OBSERVATION/SUBMISSION TO PLANNING APPLICATION

Case Reference: 324113

Re: Observation to the proposed development of open-cycle gas turbine (OCGT) and generator with ancillary equipment.

Location: Pollnagroagh and Rathmorrissy (Townlands), Athenry, Co. Galway

Purpose		PLANNING			
Title		SITE ACCESS SIGHTLINES			
Original Scale	Design/Drawn	Checked	Authorised		
SHOWN at A1	PS	ND	AJB		
Date	Date	Date	Date		
01.12.25	01.12.25	01.12.25	01.12.25		
Status	Drawing Number	Rev			
A2	PEK3-ATK-ZZ-01-DR-CE-901200	0

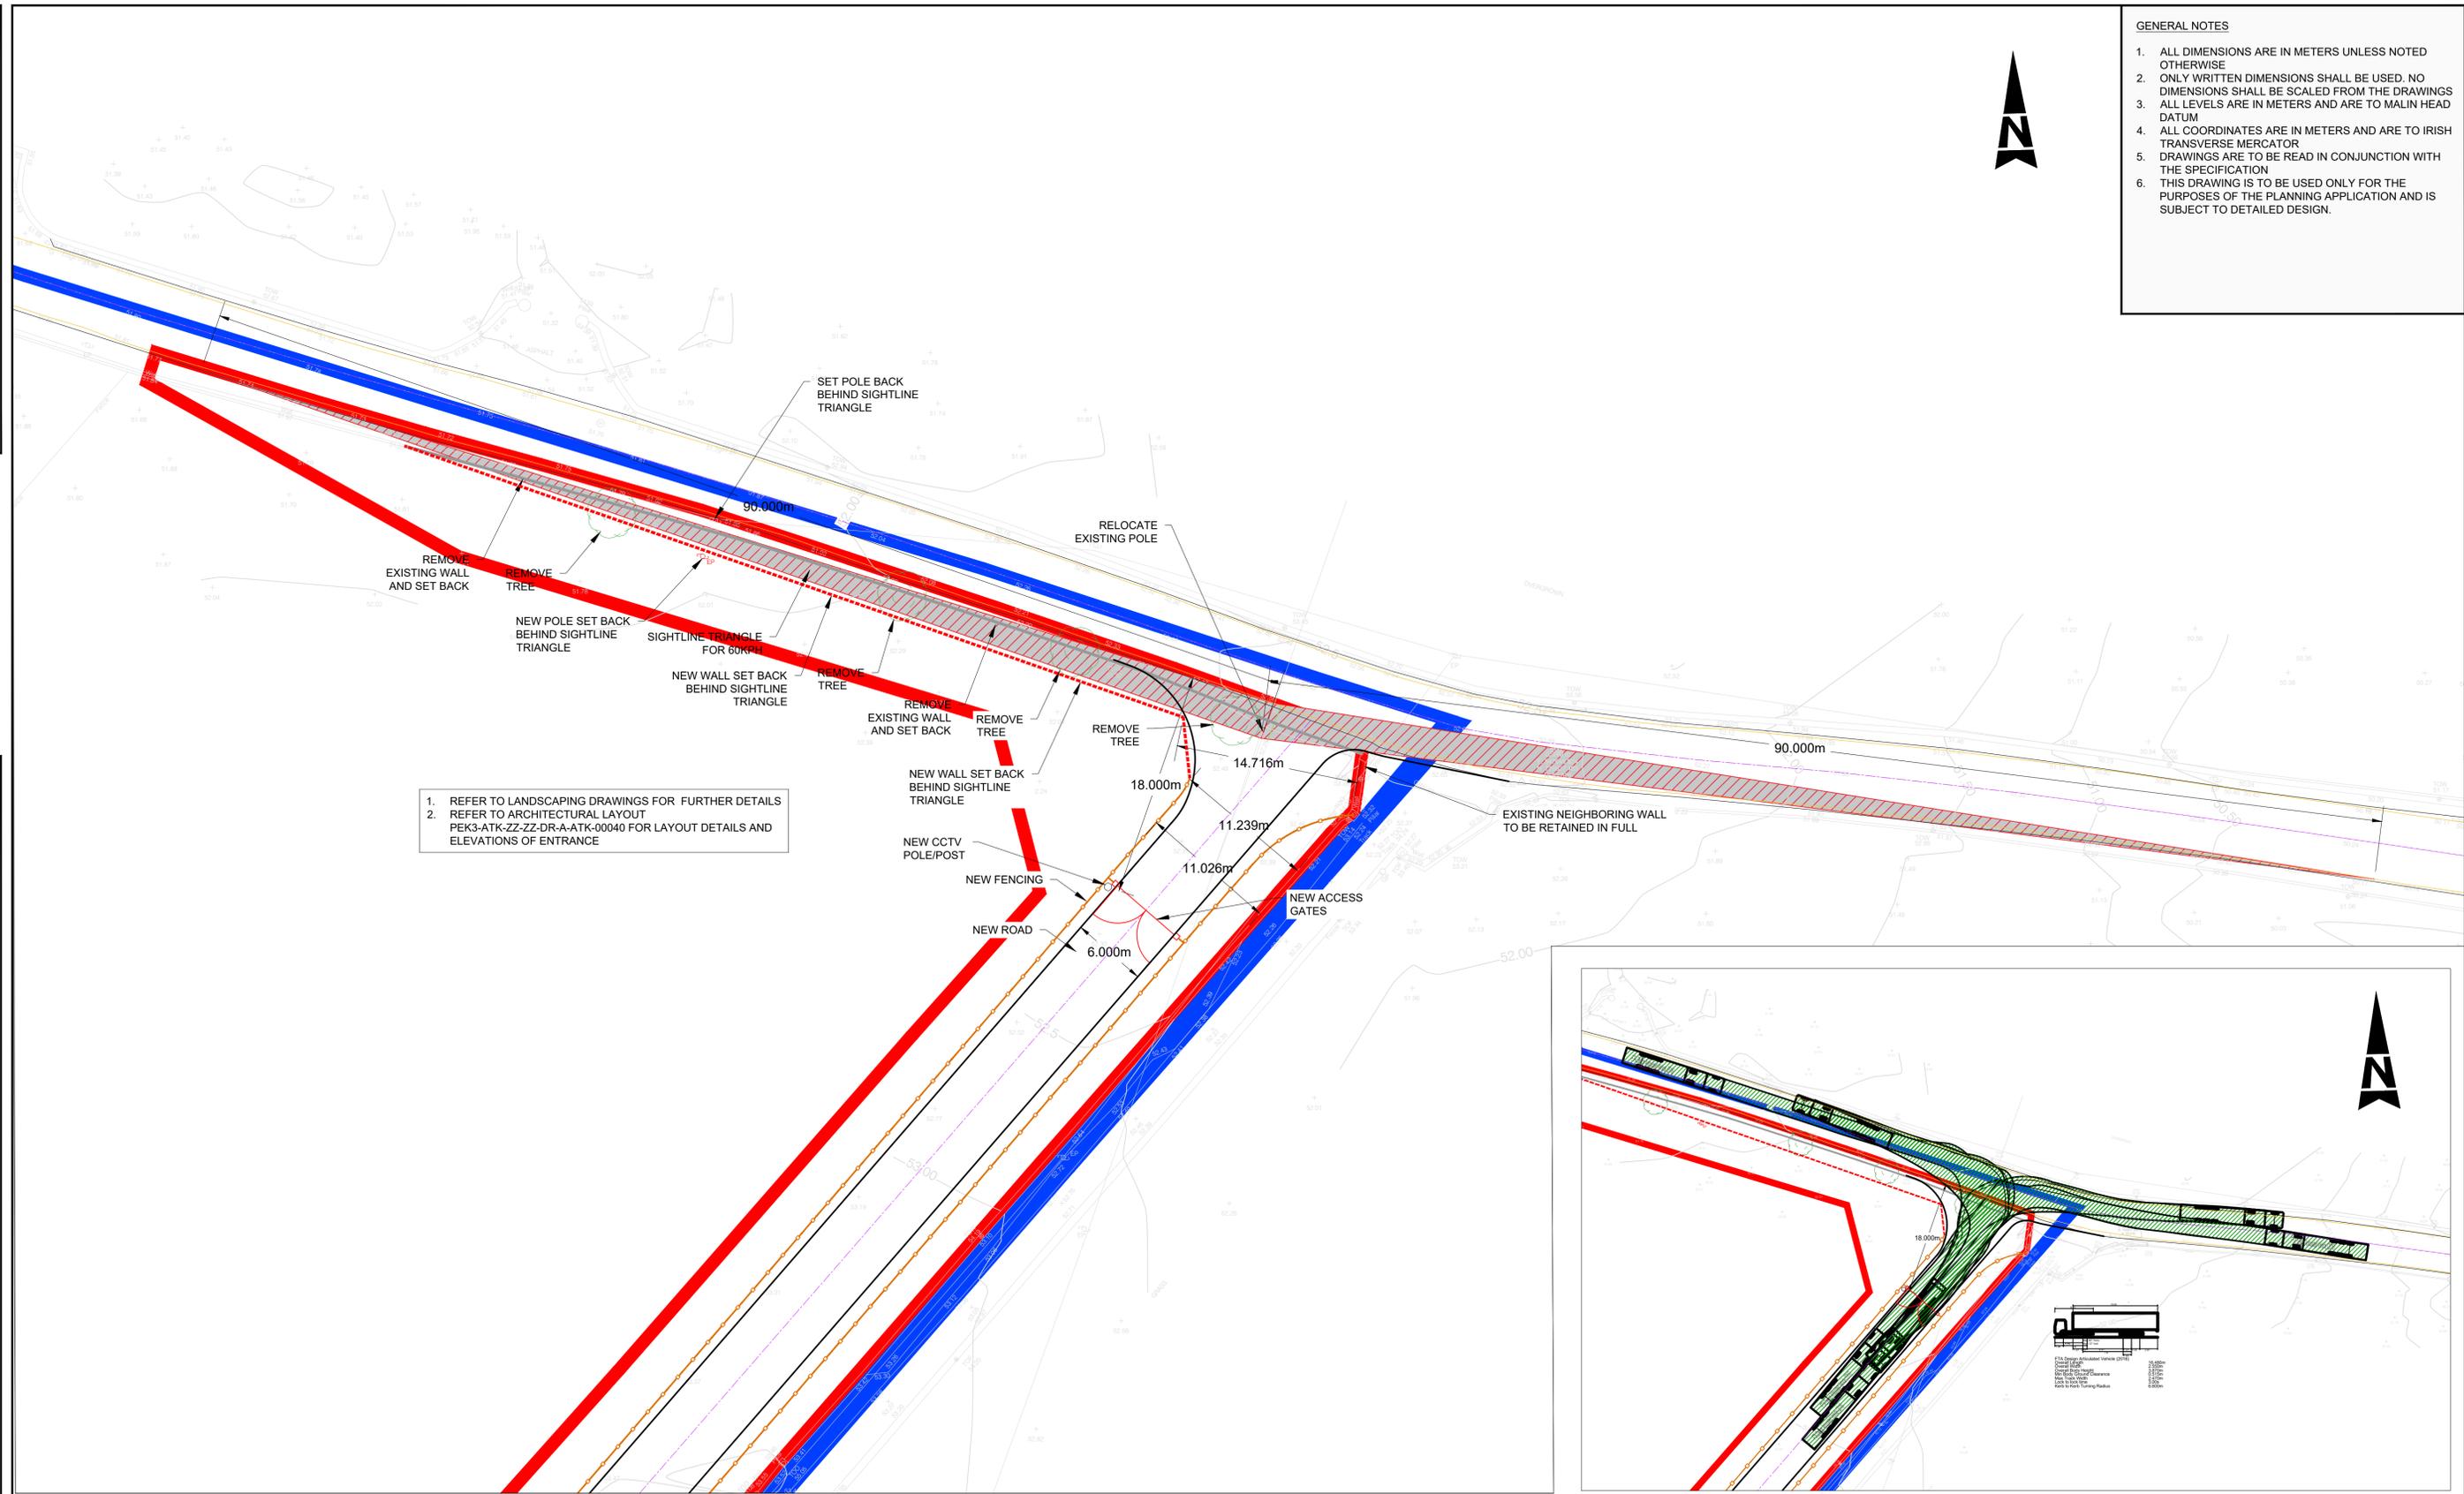
The placement of the proposed site entrance on the L3103 raises severe safety concerns due to the inherently hazardous nature of this specific stretch of road. The carriageway is critically narrow, struggling to safely accommodate two passing Heavy Goods Vehicles (HGVs), and completely lacks a hard shoulder to allow for any margin of error. Compounding these dangers are the presence of blind dips and corners, which significantly reduce visibility and sightlines for all road users. These critical safety deficiencies create an unacceptable traffic hazard that must be comprehensively addressed.

The proposed site entrance is located on an exceptionally dangerous section of the L3103. Establishing an access point at this specific location introduces an unacceptable level of risk due to several compounding hazards:

- Severely Restricted Width: The road is currently too narrow to safely permit two Heavy Goods Vehicles to pass simultaneously.
- Absence of a Hard Shoulder: There is no safe refuge or margin for error for manoeuvring vehicles.
- Critically Poor Visibility: The immediate area is affected by blind dips and blind corners, severely compromising driver sightlines.

These immediate dangers constitute a severe threat to public safety and require urgent and mandatory remediation.
